July 1st, 2019

RE: Existing Tank Application # BRES1906-0029

SITE PLAN APPROVAL *Revised*
 DISTRICT *RA 30* USE *screened porch*
 #BEDROOMS *—*
6-11-19 *K* *A.*
 7-9-19 ADMINISTRATOR

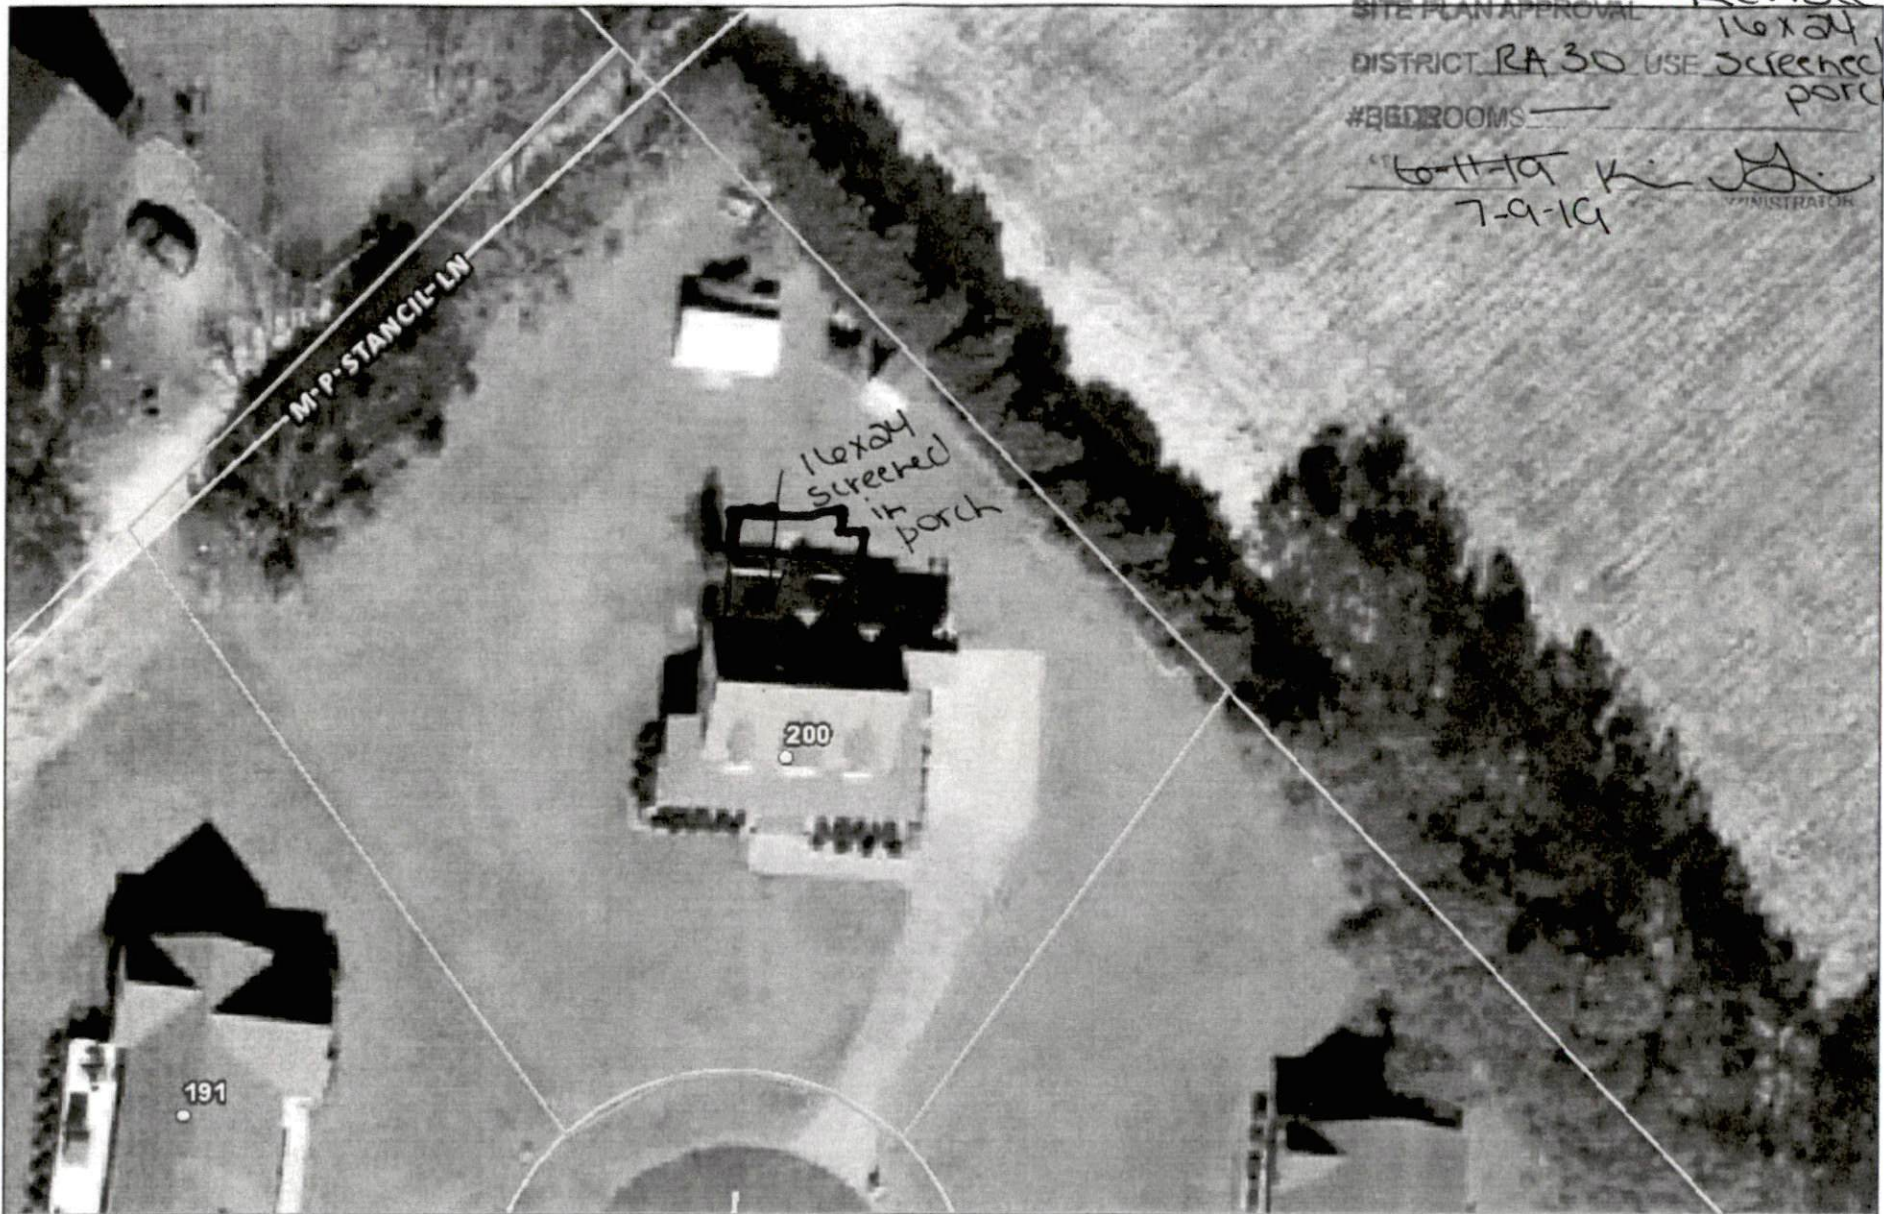
4. Other – Proposed covered porch to close to existing septic area. Porch shall be revised to meet 5ft septic setback.
